GRANDVIEW FILING 2 WATER AND WASTEWATER CONSTRUCTION D

D.R. HORTON - GRANDVIEW RESERVE SANITARY SEWER LIFT STATION DESIGN & PERMITTING SERVICES
 EL PASO COUNTY PEYTON, CO

EROSION AND GRADING CONTROL PLANS
 COVER SHEET

SHEET
C110

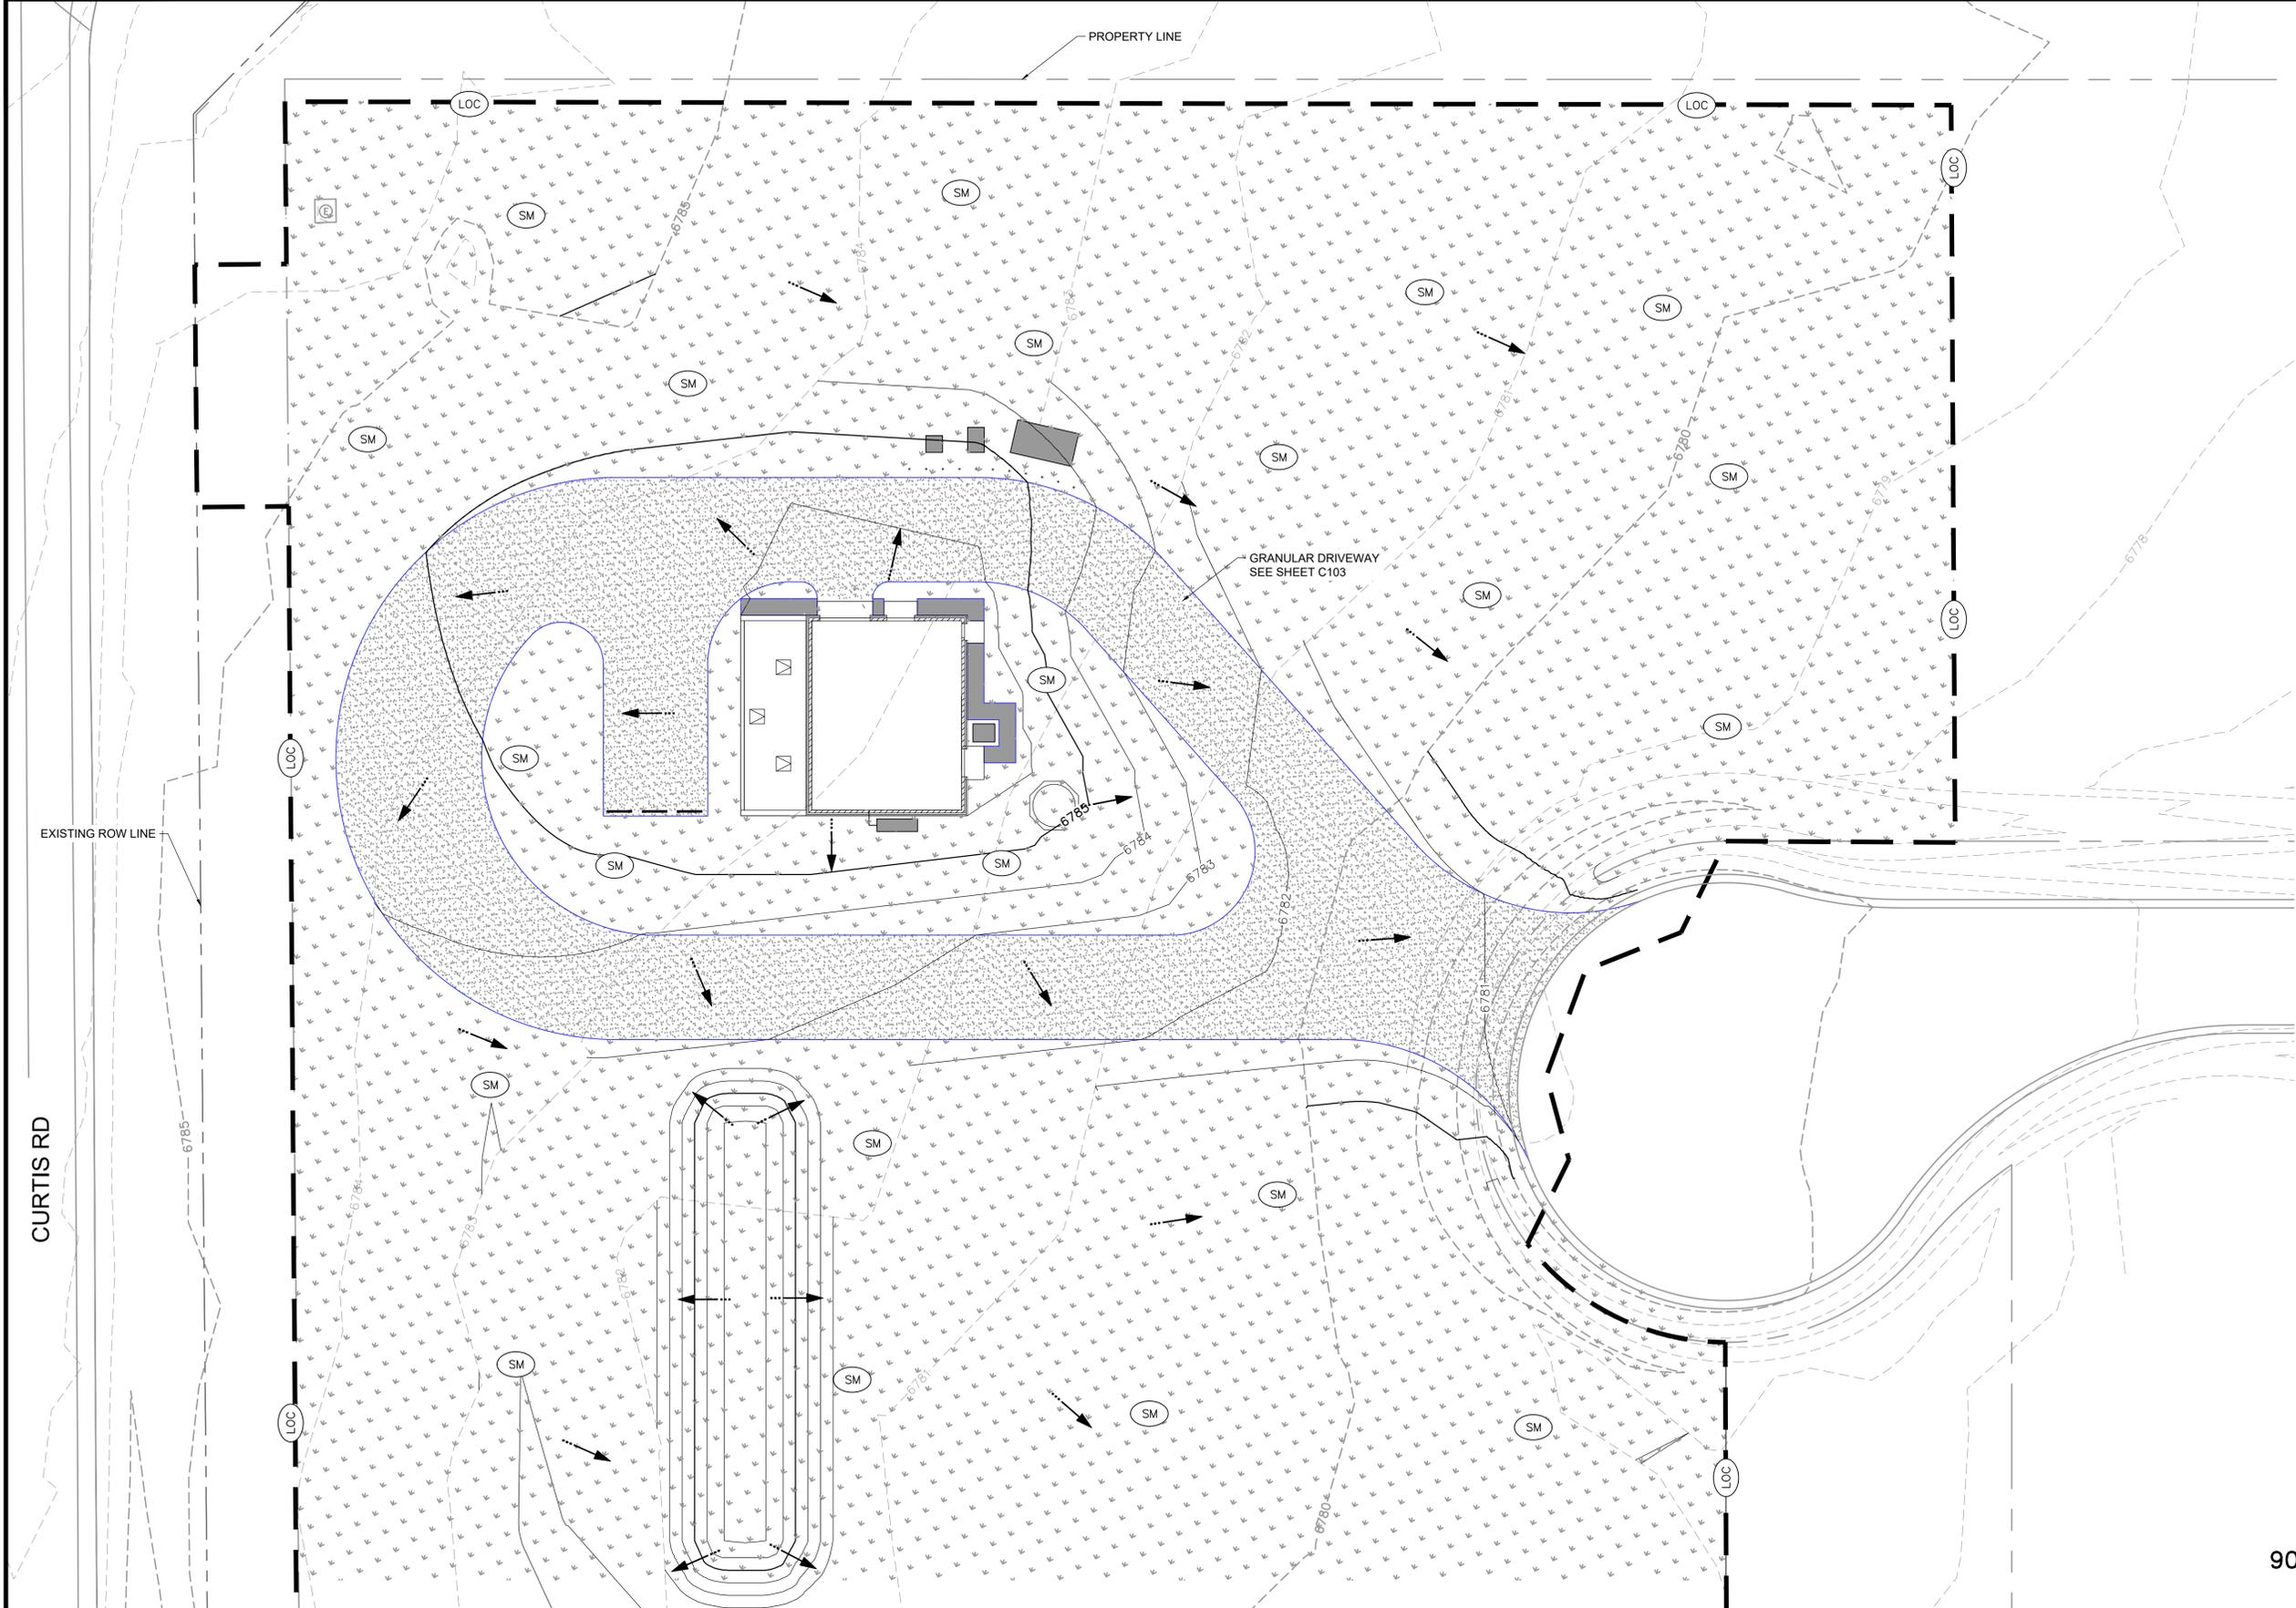
Page Label	Comments	Author	Date	HR Green Response
C109	File Number: PPR2421	ashmathy	7/29/2024	Added
C109	<p>Please include:</p> <ul style="list-style-type: none"> - Show an image the property as a whole not just a zoomed in portion -The existing zoning of the subject property and the existing zoning of surrounding properties. - Title "Substitute Landscape Plan" -Table depicting what is provided vs required -Sight distance triangles and any plantings, signs, walls, structures, or other visual obstructions within the triangles where applicable. -The location, type, size, and quantity of major existing plant materials meeting the plant type requirements, including all vegetated ground cover areas, shrubs, and trees, with information as to which materials are proposed to be removed and which shall be retained or relocated. -All proposed ground cover areas shall be identified, including the types and amounts of living plant materials to be used and the size and depth of non-living materials. The manner in which any lawn areas are to be established (for example, by sodding or seeding) shall be indicated. <p>The landscape treatment of all adjacent right-of-way areas, as well as the owner/ developer's property, shall be identified.</p> <p>Location of:</p> <ul style="list-style-type: none"> -ROW (depict ROW dedication too) -Easements - surrounding zoning districts 	ashmathy	7/30/2024	<ul style="list-style-type: none"> - Vicinity map added to landscape sheet. Viewport adjusted. - Labels added. - Title revised. - Table added. - Not applicable. - No major existing vegetation. - Existing ROW's to be preserved. Any disturbed areas to to be revegetated and returned to original condition. - ROW shown and labeled. - Easements shown and labeled. - Labels added.
